Planning Services  
Key Sites Assessments  
Contact: Ellen Mannix  
Phone: 02 8275 1031  
Email: [Ellen.Mannix@planning.nsw.gov.au](mailto:Ellen.Mannix@planning.nsw.gov.au)  
Our Ref: SSD 8999

**Mixed use development, 35 Honeysuckle Drive, Newcastle (SSD 8999)  
Response to Submissions**

## **ATTACHMENT A**

Drawing Name
Floor Plan - Basement 02

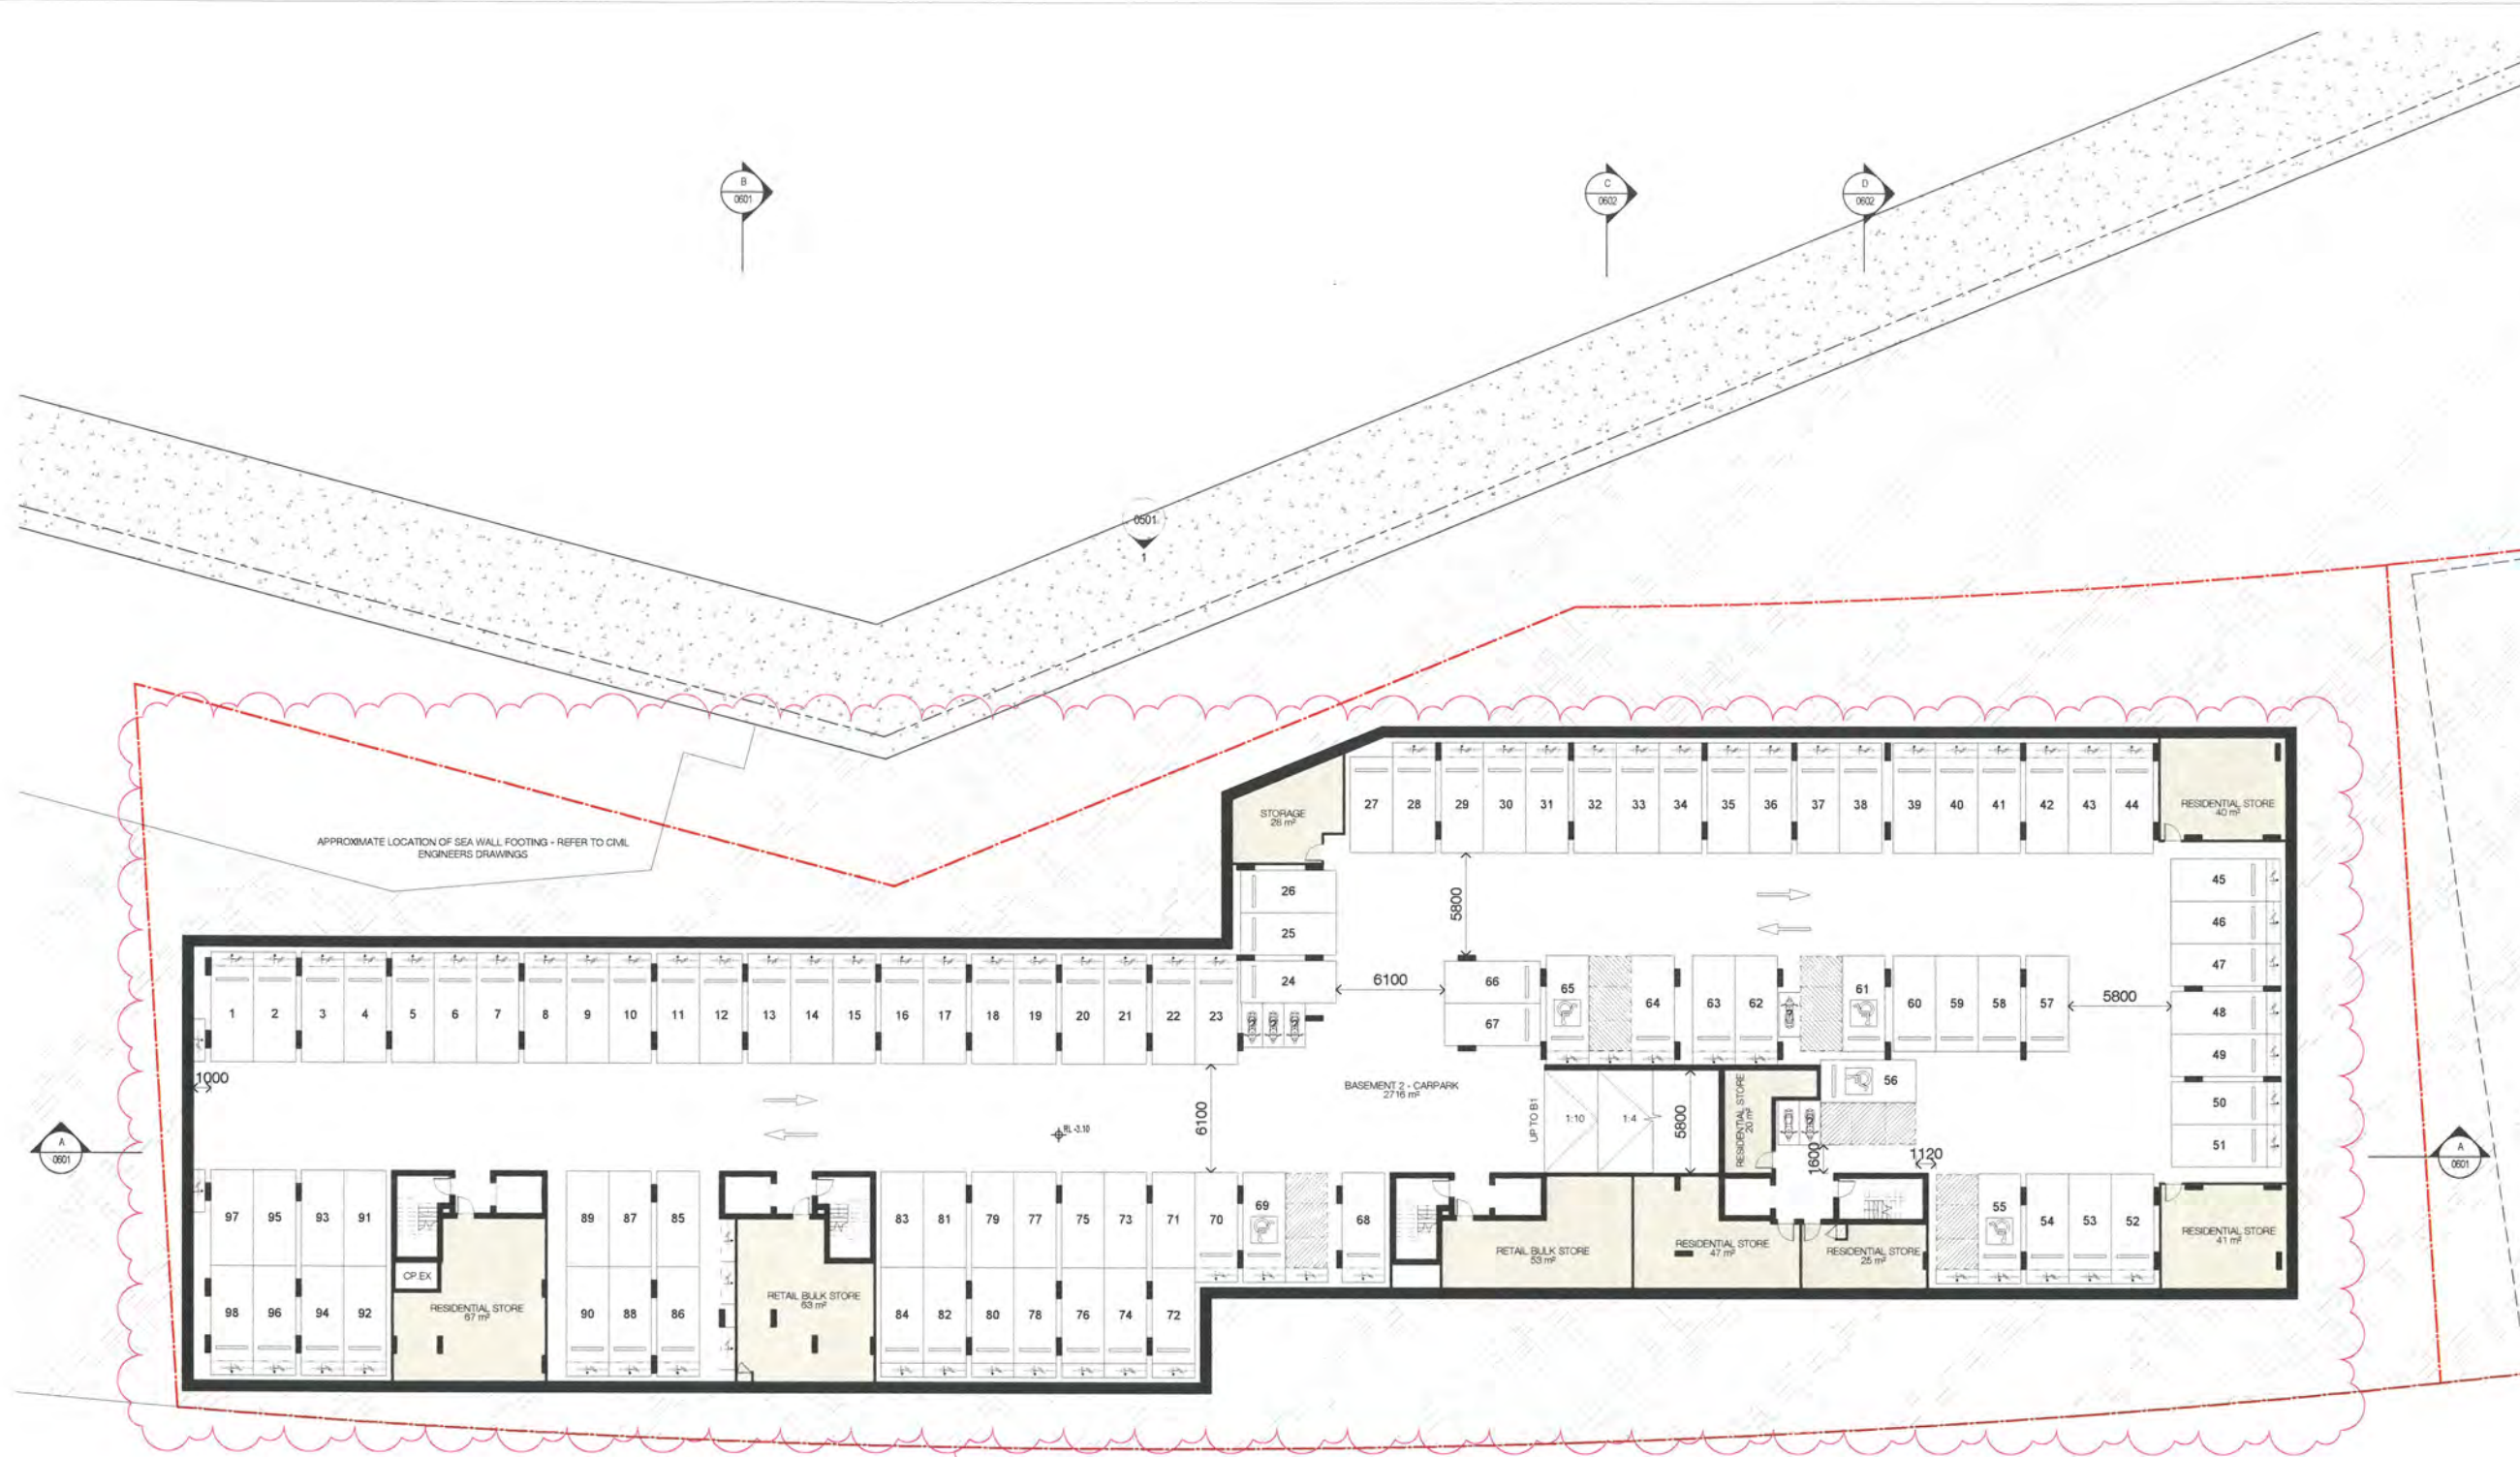
- objective 4G-1 - Internal storage to units B101, B107, B201, B208, B301, B401, B408, B501, B508, B601 and B608. Notate the size and allocation of the external storage areas on the basement plans. Clarify the use of the large storage rooms in the basement.

- Provide owner's consent for the awning elements of Building A located outside the site boundary.
- Remove the reference to 24 hours, 7 days per week operating hours in the Plan of Management.
- The submitted plans require the following additional details:
  - driveway width
  - ground levels and floor levels on sections and floor plans for the rooftop elements of the Landscape plan
  - number the car spaces in the basement.

Section AA

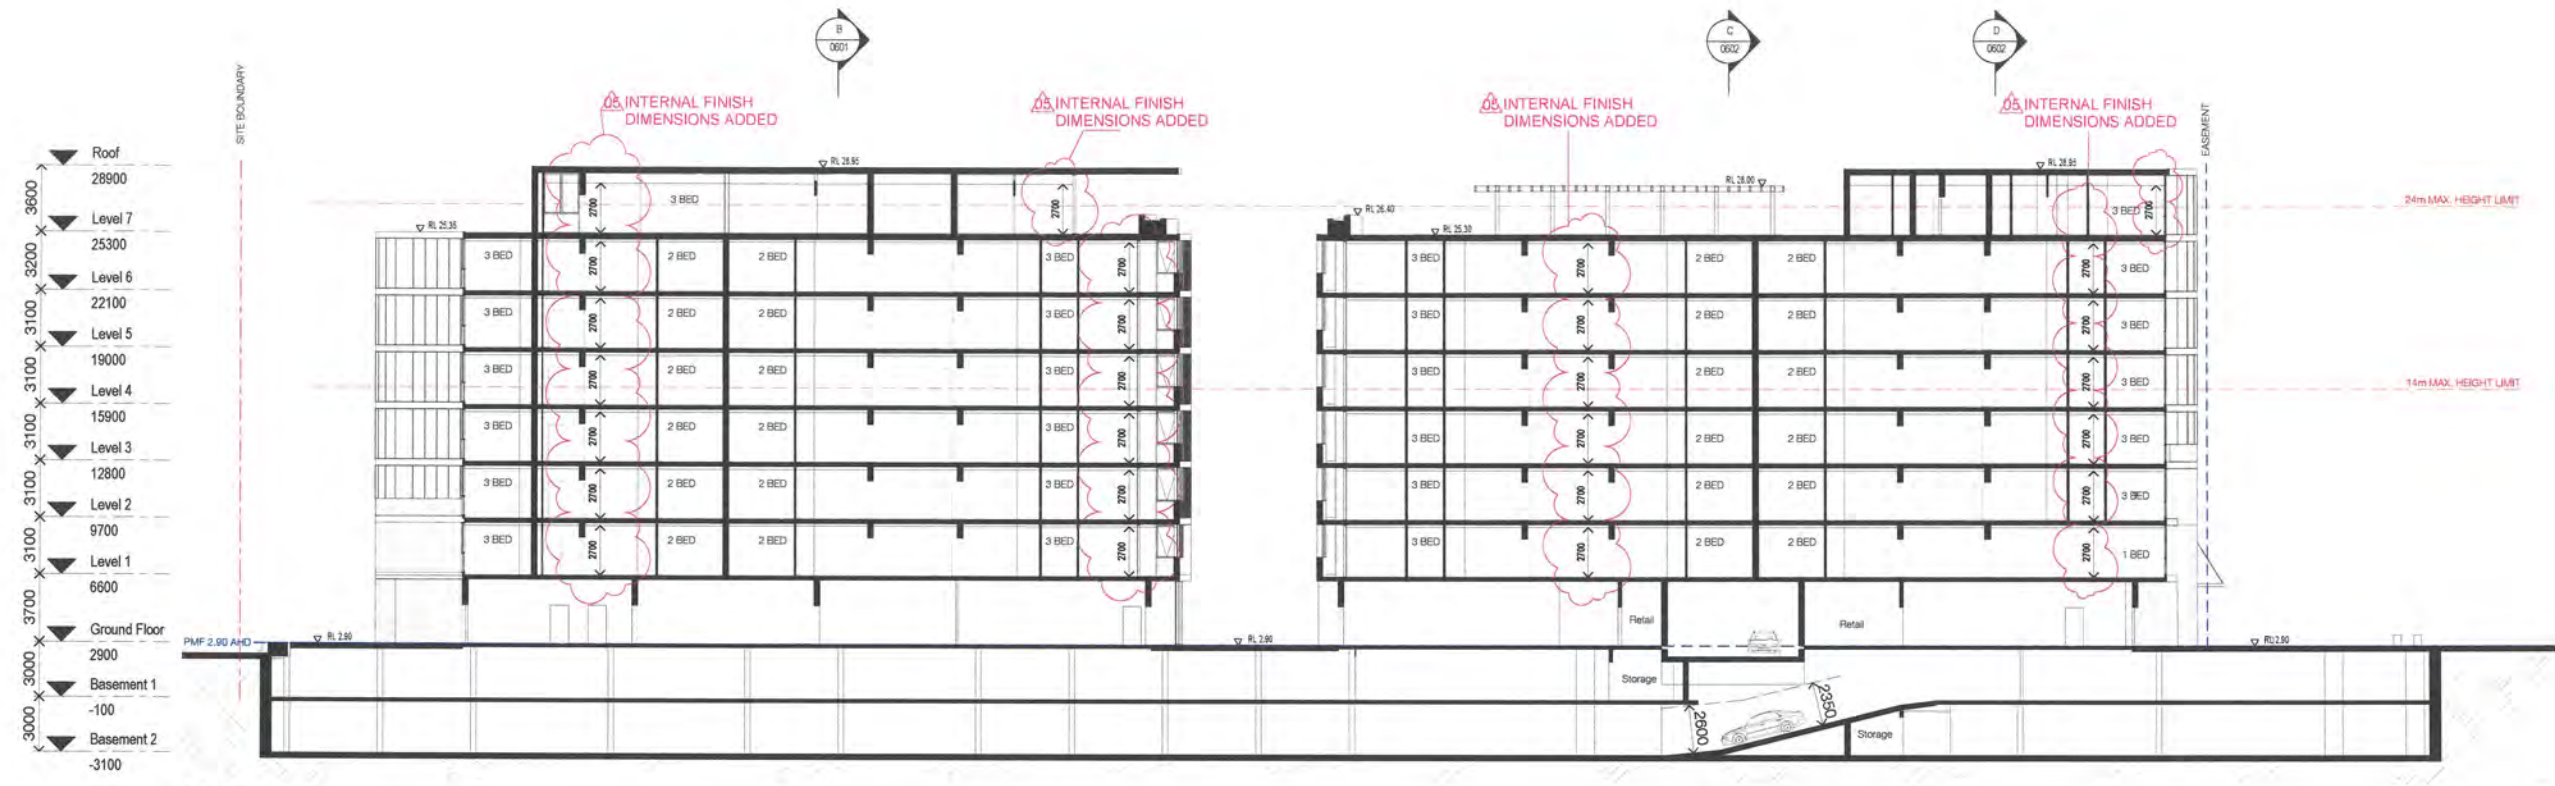
- Demonstrate the maximum building height measured from the Natural Ground Level on the section plans and the corresponding maximum allowable building height

- The following is required to be notated on the plans to demonstrate consistency with the minimum recommendations contained within the ADG:
  - objective 4C-1 - Internal floor to ceiling heights on section plans

Drawing Name
SEPP 65 Analysis - Communal Space

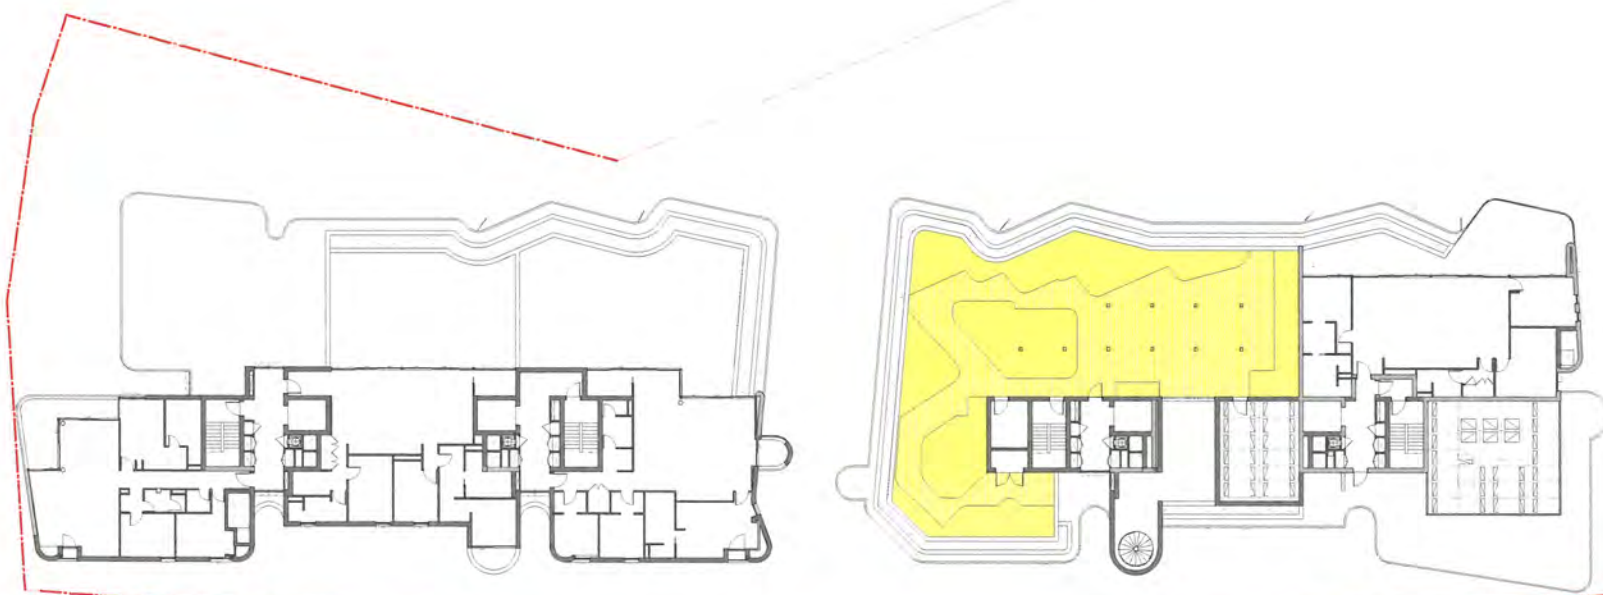
- Provide further justification for the proposed communal open space having regard to Objective 3D-1 of the ADG. Specifically, equity for residents of building A to the rooftop space, proximity to public open space and how the communal open space and public space will operate. Further clarification is also required as to why certain areas of the ground floor have been deemed communal open space.

APPENDIX A – PLAN OF SUBDIVISION

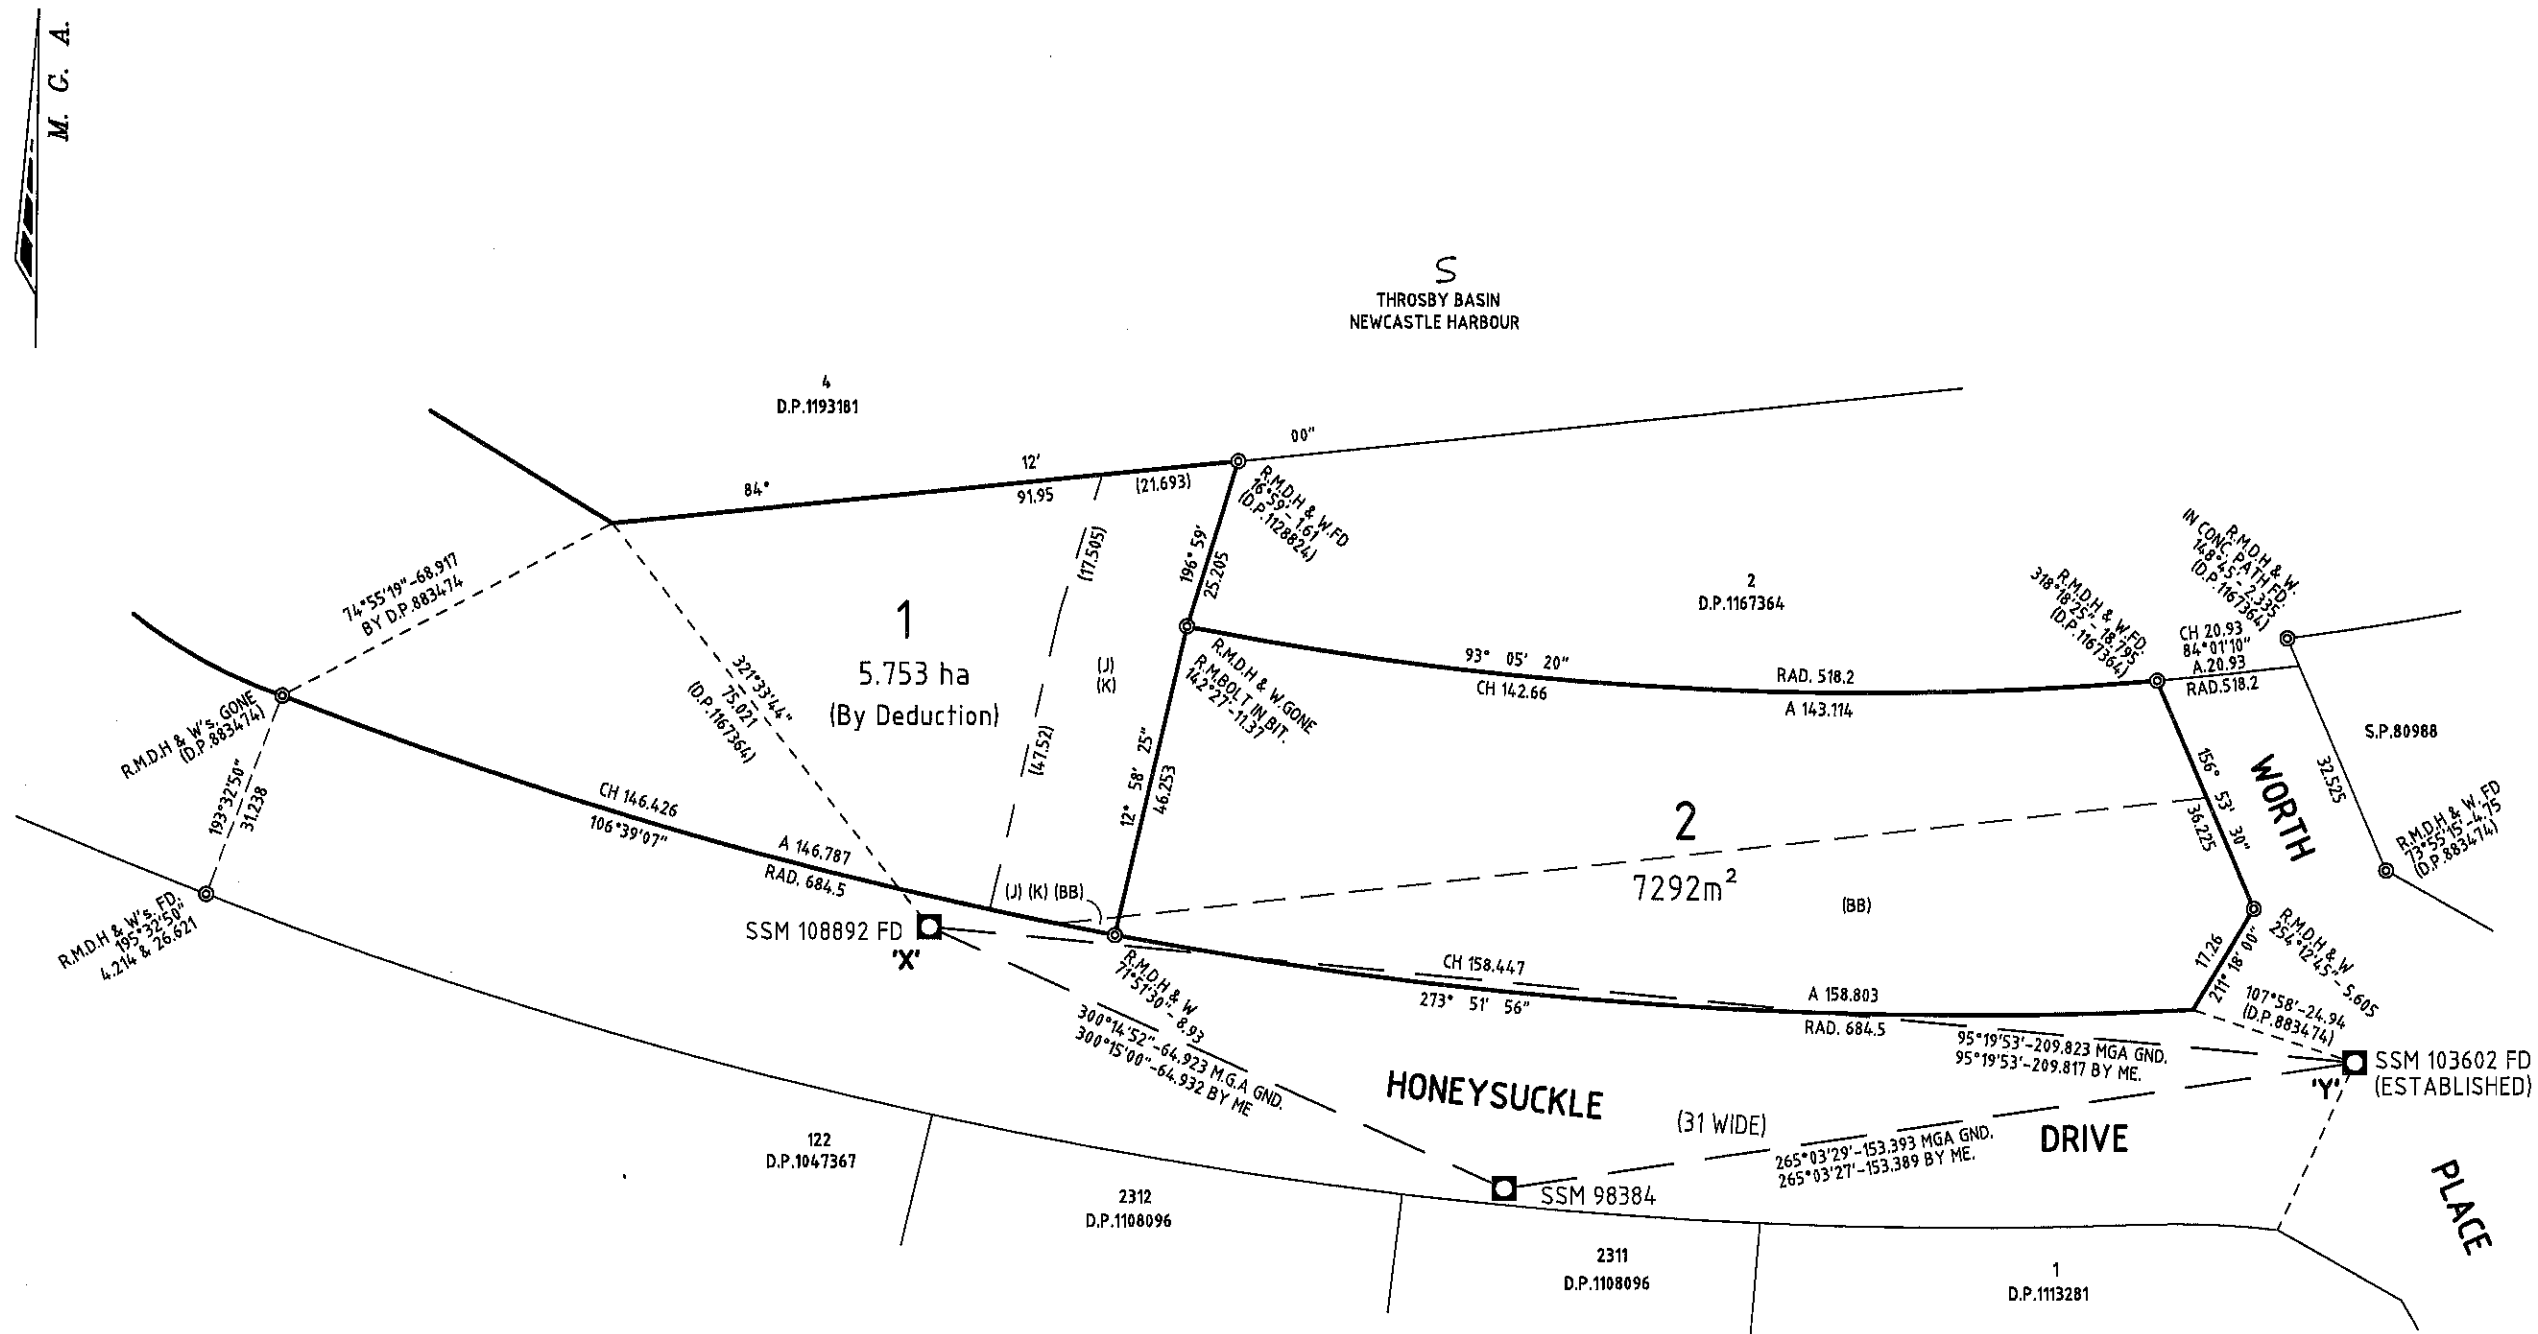
- Provide details regarding the proposed subdivision including the time frame and dimensions on the subdivision plan demonstrating the proposed boundaries.
